**From:** [Linda Scalzo](#)  
**To:** [Deb Estrada](#)  
**Subject:** Purposed East Seattle Development  
**Date:** Wednesday, January 24, 2024 10:40:58 AM  
**Attachments:** [EAST SEATTLE updated concerns 2024.docx](#)

## EAST SEATTLE / BOYS & GIRLS CLUB PROPERTY

Builders asking for 14 houses on 2.88 acres

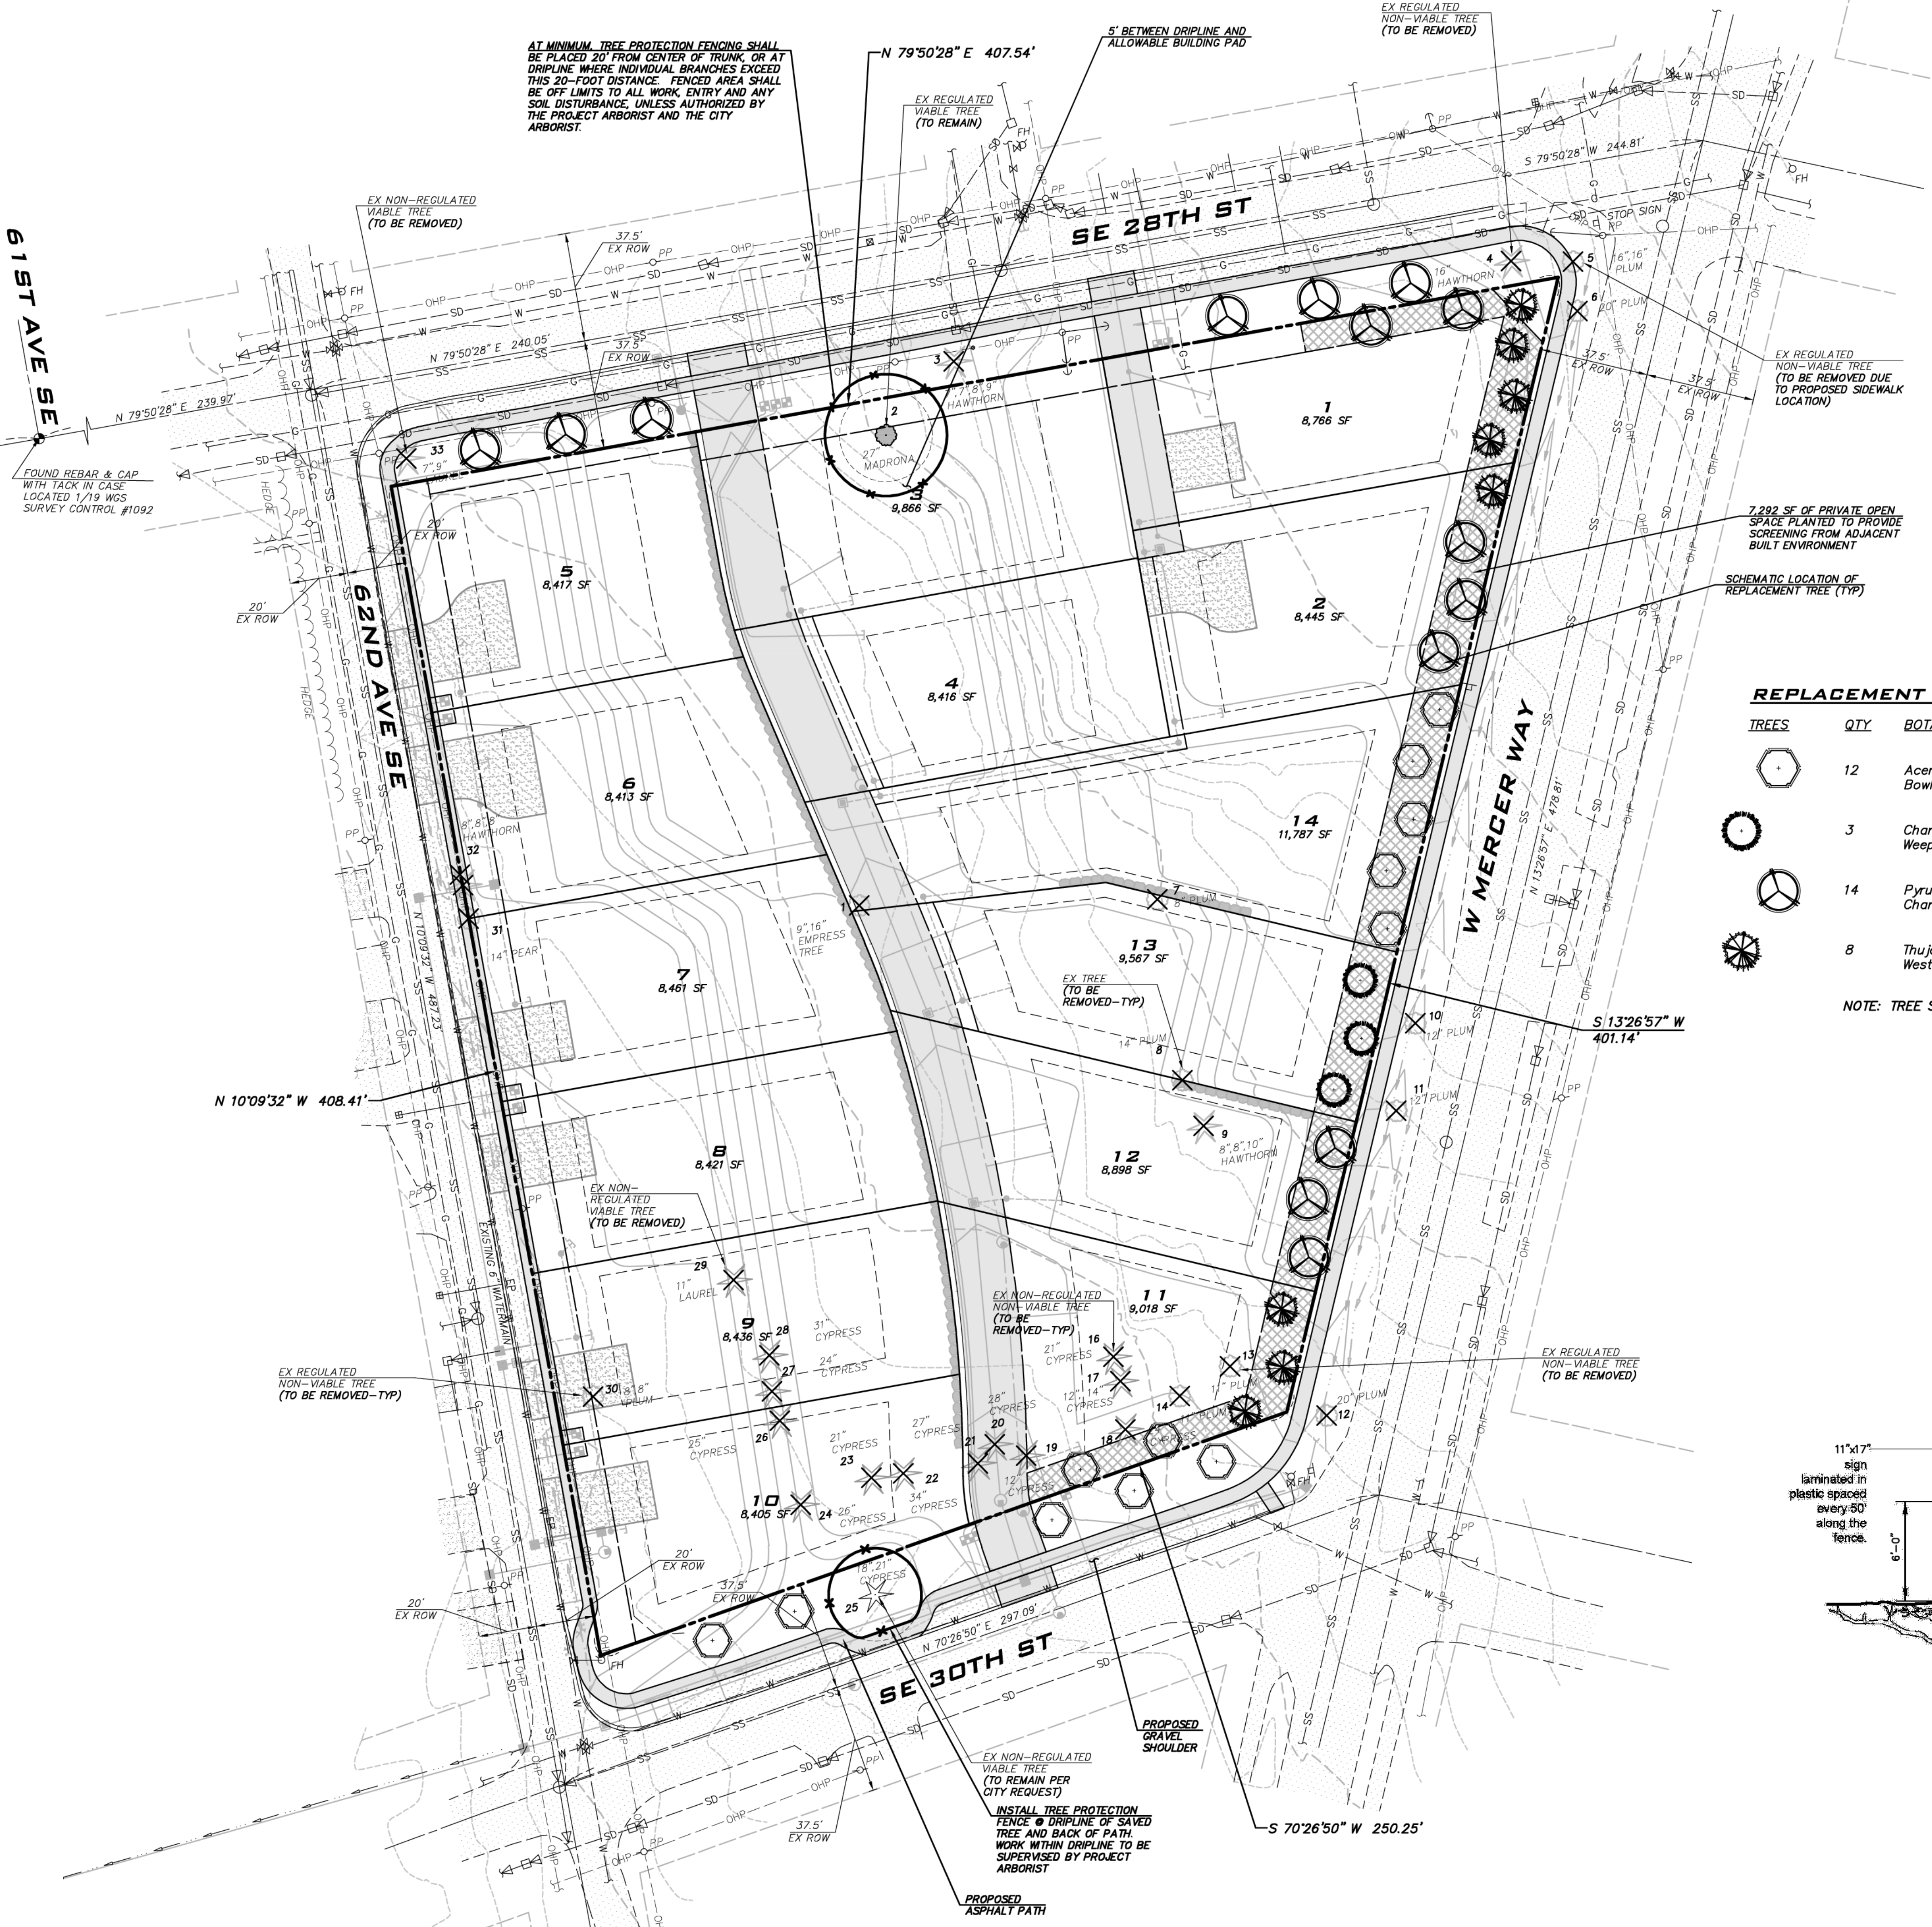
- Plant more plants on individual lots and shared green space to blend development into neighborhood. Plant dwarf varieties of trees which don't mature pass the height of the houses so they don't block people's views.

Also very concerned about removing all the trees before house permits go through. Find it hard to believe that almost all the trees are diseased.

- There should be a uniform fence along W Mercer and 62<sup>nd</sup>. No one wants to look into people's back yards. Most of the proposed trees along W Mercer are deciduous and don't form a hedge like border. Curious about the choice of 4 Weeping Nootka False Cypress along W. Mercer. They don't seem to fit with the look of the other trees.
